**David Mooney - FW: Response to Submissions, Borg Oberon**

**From:** Alison Collaros <Alison.Collaros@water.nsw.gov.au>  
**Sent:** Thursday, 10 November 2011 3:31 PM  
**To:** Tony Preston; bgohl@pb.com.au  
**Cc:** Tim Baker; Vickie Chatfield  
**Subject:** Controlled Activity Application - Borg Panels, Oberon  
**Attachments:** form\_licence\_wmaf036\_controlled\_activities\_guide.pdf; form\_licence\_wmaf036\_controlled\_activities.pdf

## TYPICAL SWALE DETAIL SCALE 1:25

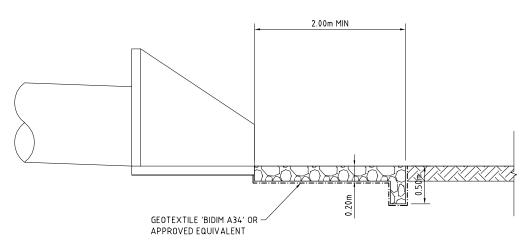
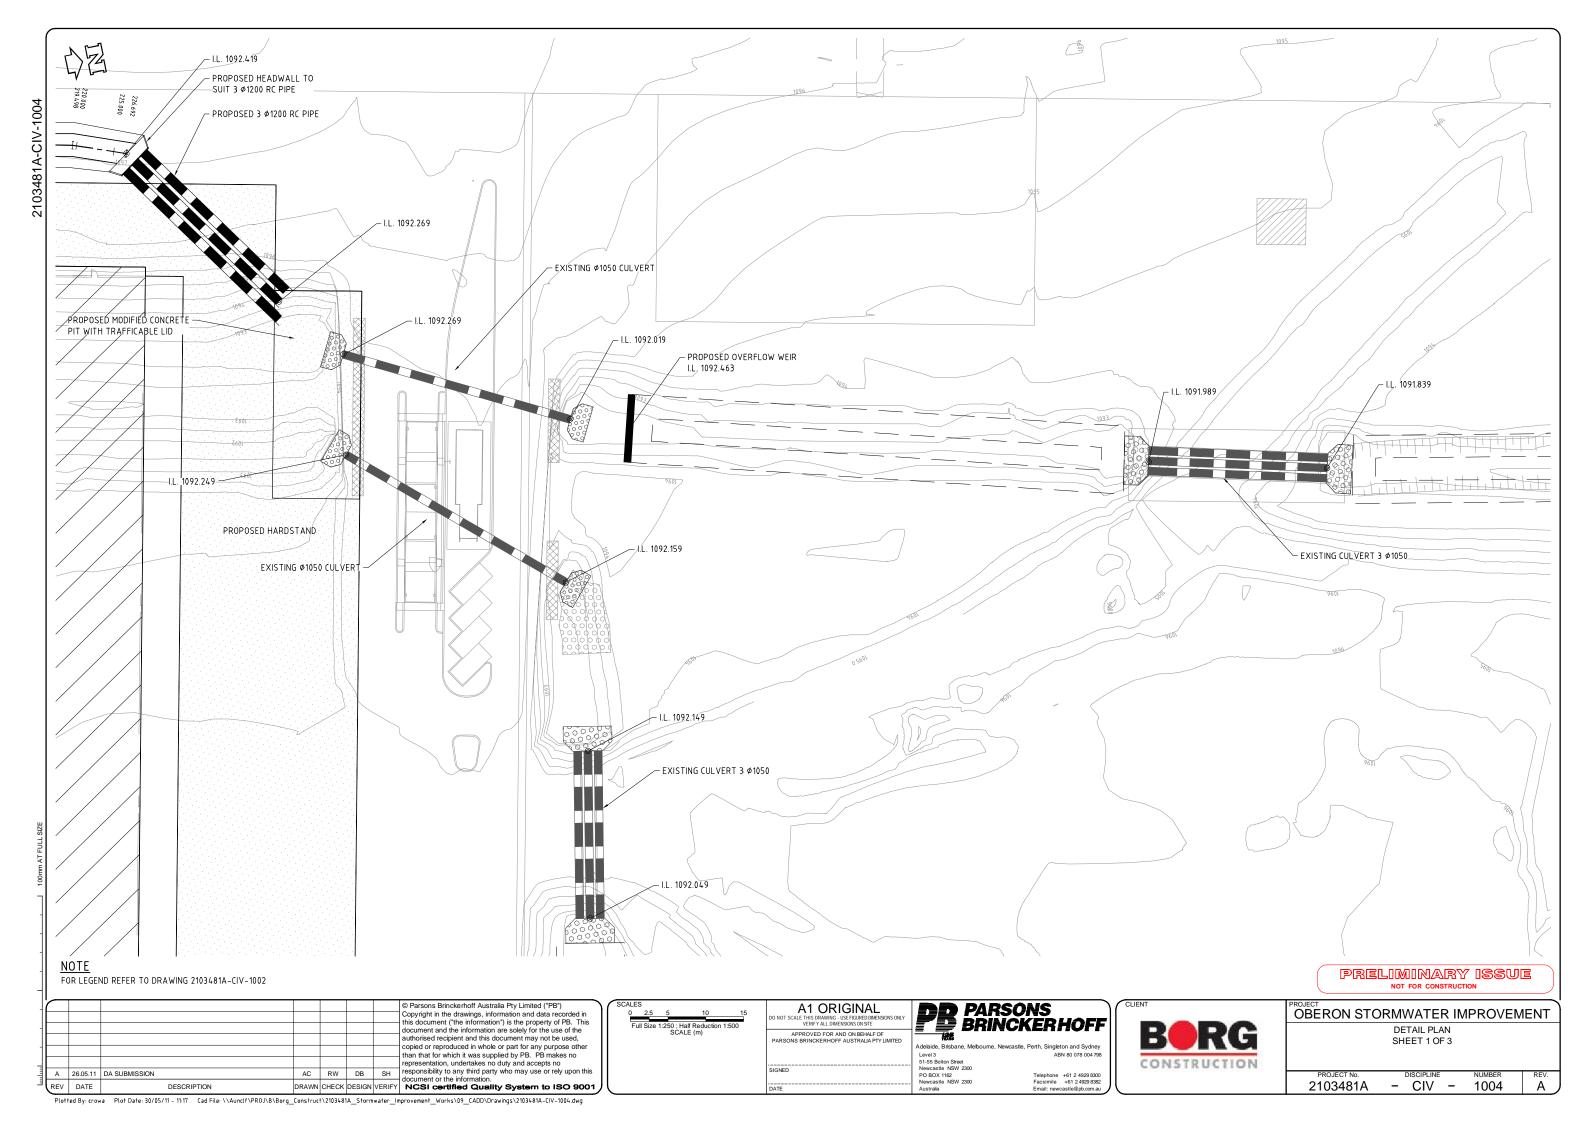
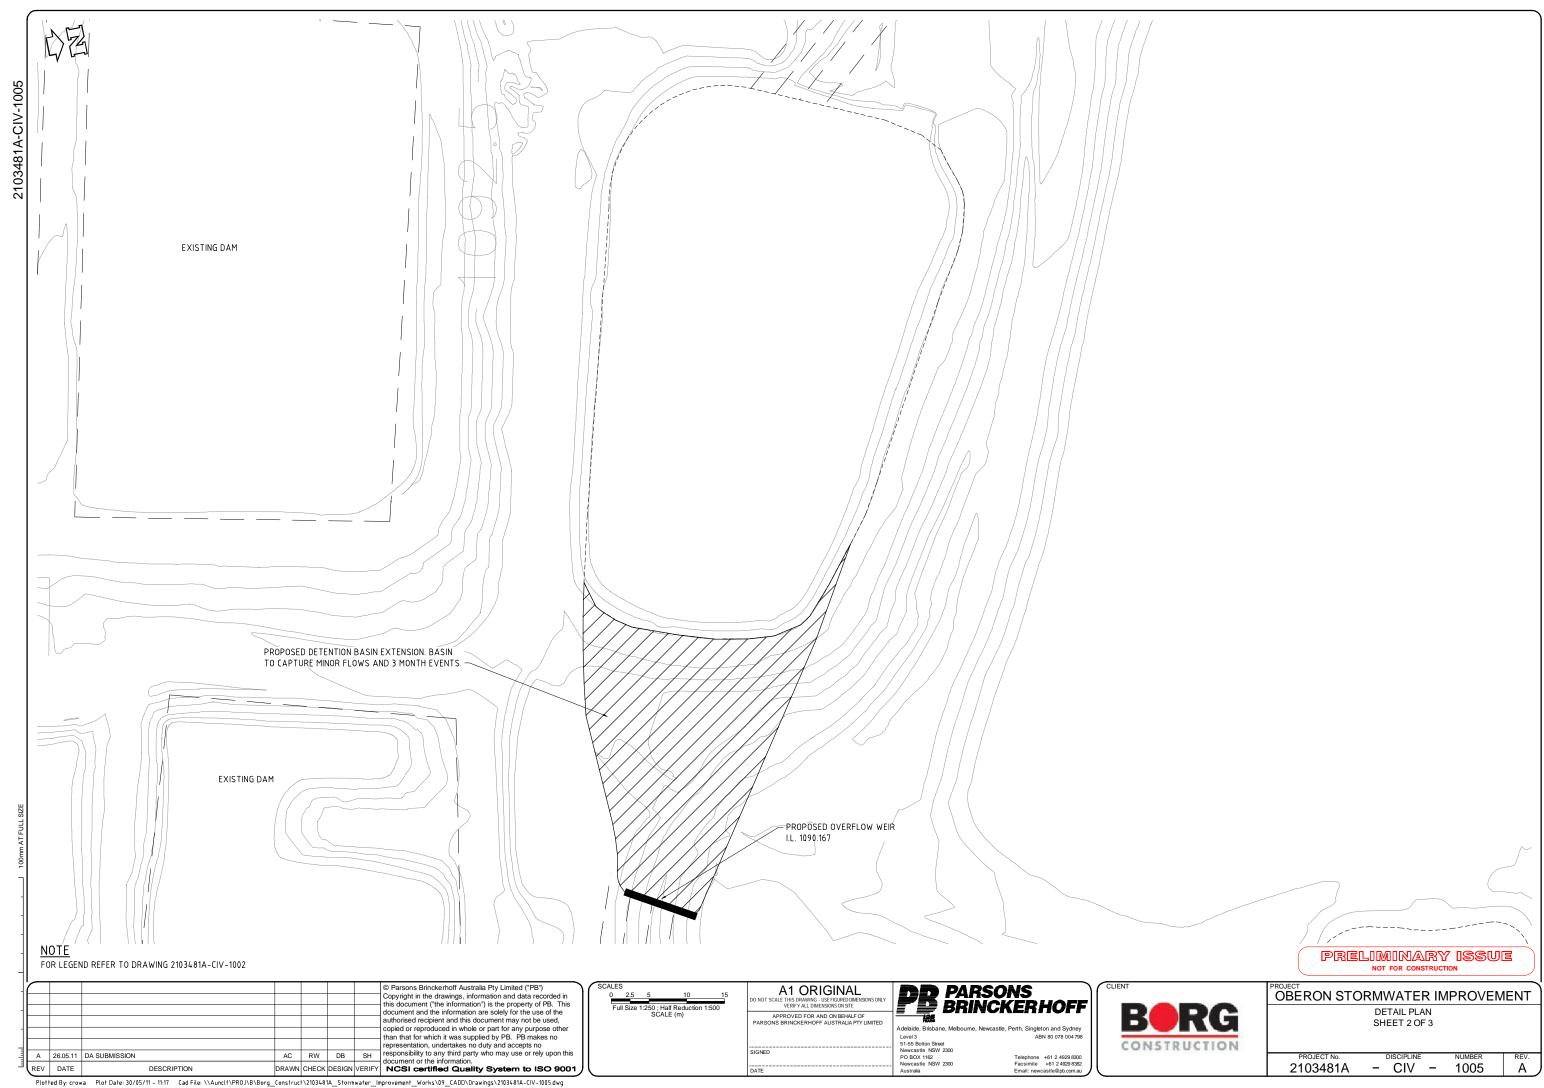
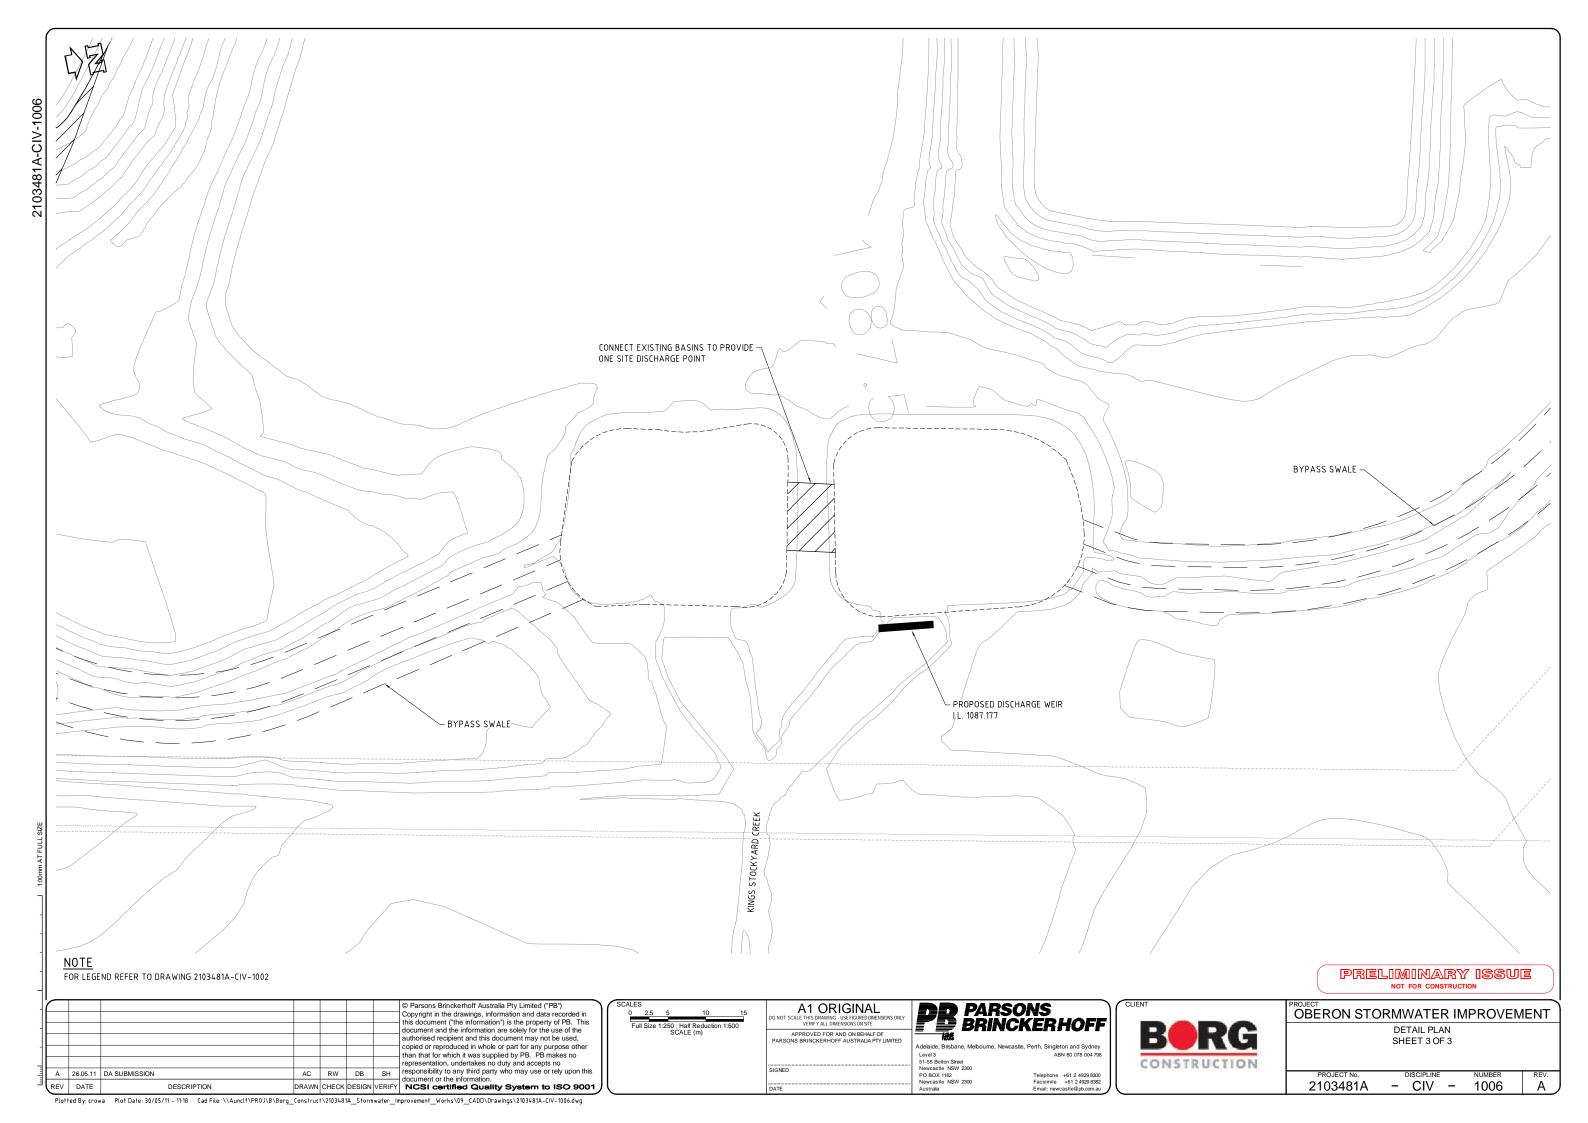
Please find attached our response to submissions. There were 4 submissions on your project and the main issue that needs to be addressed is the drainage swale specification, as outlined in the NSW Office of Water submissions.

4. a proposed maintenance schedule to ensure vegetation survival within the swales and to inspect for potential scour/undermining of the shotcrete walls
